CITY OF ALBUQUERQUE

May 29, 2014

**Re: I40 South and Unser Mini DMP
Engineer's Stamp Date 4-21-14 (K09D026)**

Based upon the information provided in your submittal received 4-21-14, the above referenced report cannot be approved for Drainage Masterplan until the following comments are addressed:

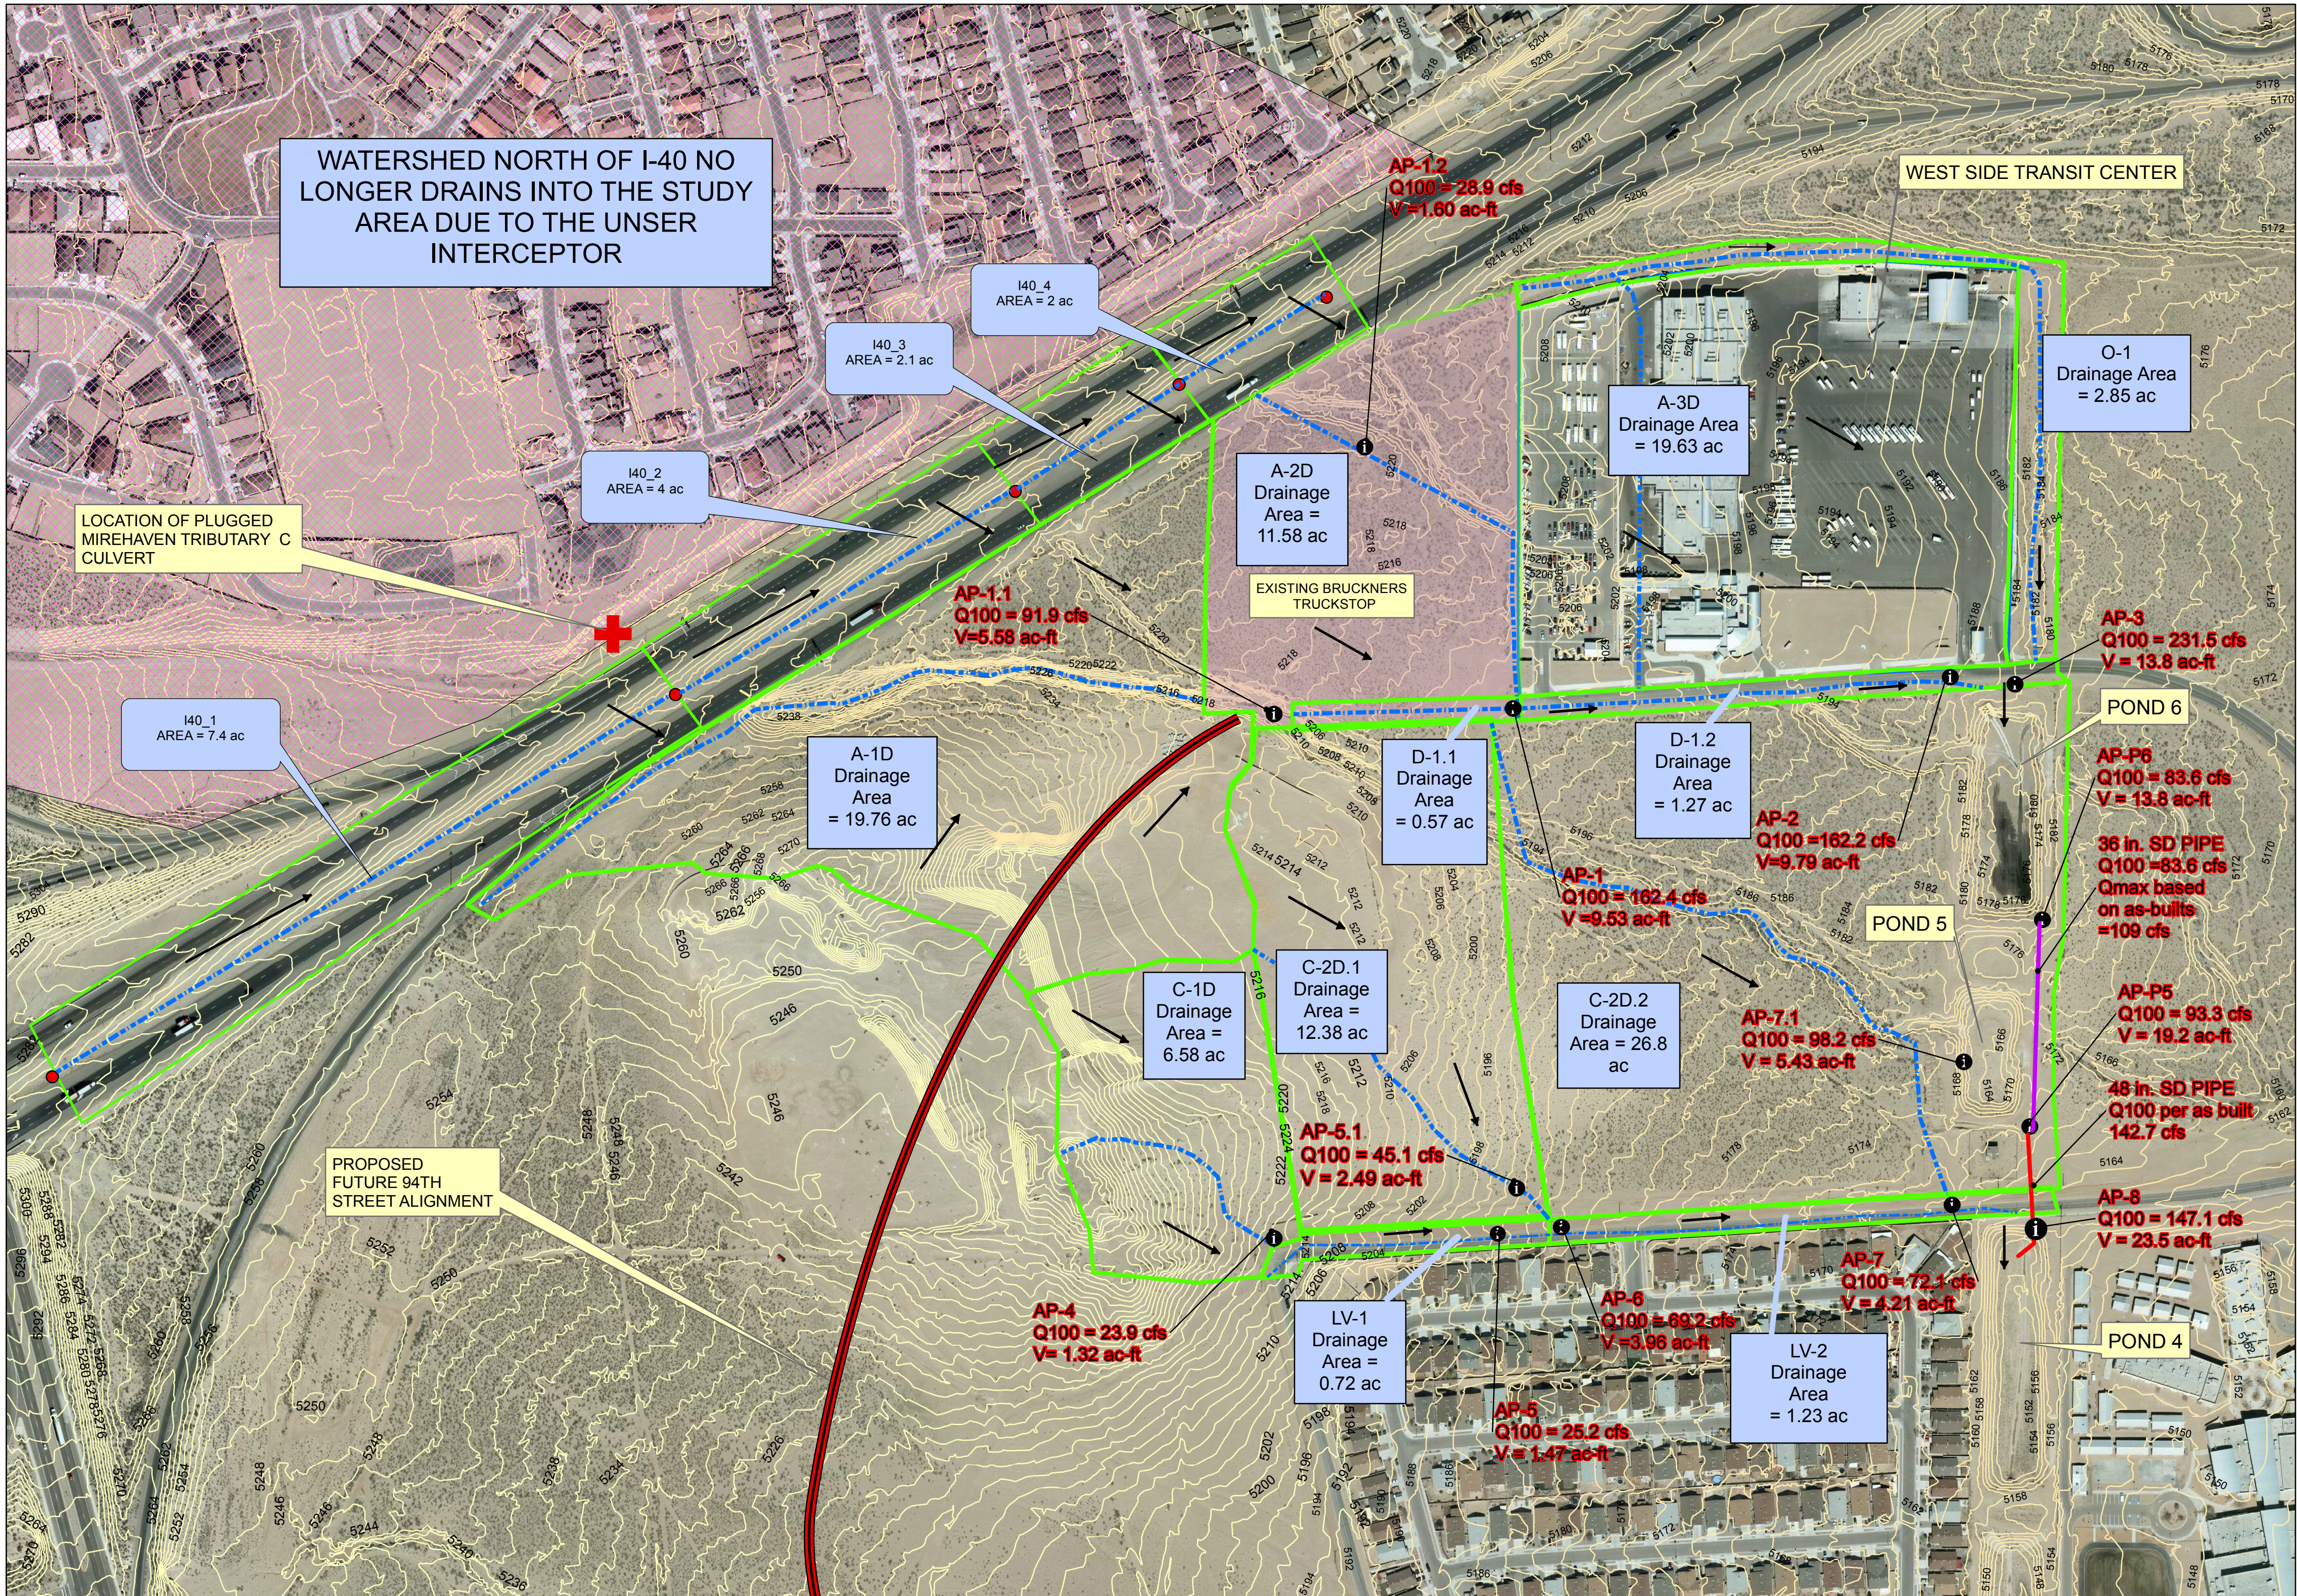
2. Show the new alignment of 94th/Daytona per the Avalon Unit 5 plat. This will most likely change DEVEX basins A-1D and C-2D.1 by removing the piece east of 94th out of basin A-1D and putting this area into basin C-2D.1

3. On the existing and DEVEX plates, it would be beneficial to replace the HEC-HMS input parameters table with a table that provides curve number, soil group, volumes and flows per basin.

7. The eastern boundary for basin C-2D.2 in the developed condition should be near the east side of the ponds.
8. Provide documentation of how the program uses the information when information is included in the Curve Number and the Impervious boxes.

I-40 SOUTH AND UNSER
DIVERSION MINI DMP
PLATE 1

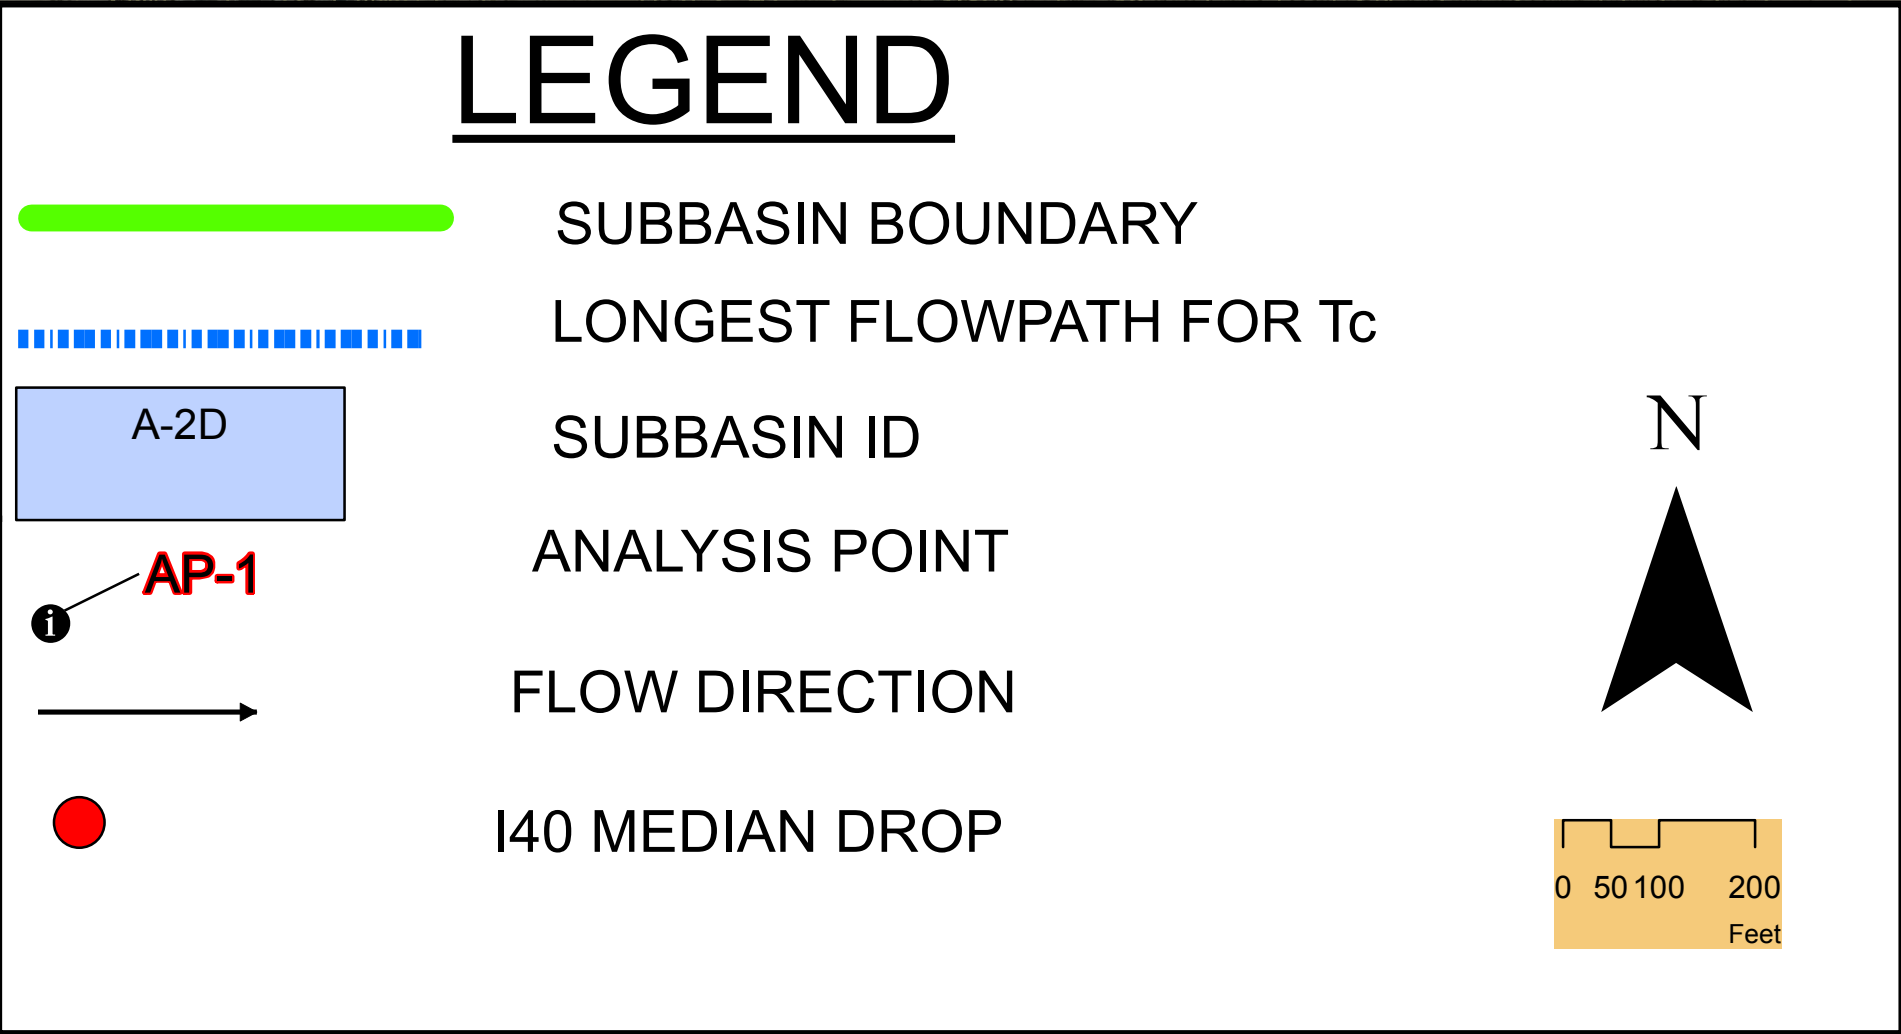
4. There should be an eastern boundary for basin C-2D.2. Why would platting change the existing basin boundaries?
5. Include the offsite basins and entry location shown in Brucker's drainage report by Tierra West as well as the offsite basin on the north side of I-40 that drains to the pipe near the existing box culvert that caused the flooding problem at Bruckner's. This offsite basin extends west to 98th street
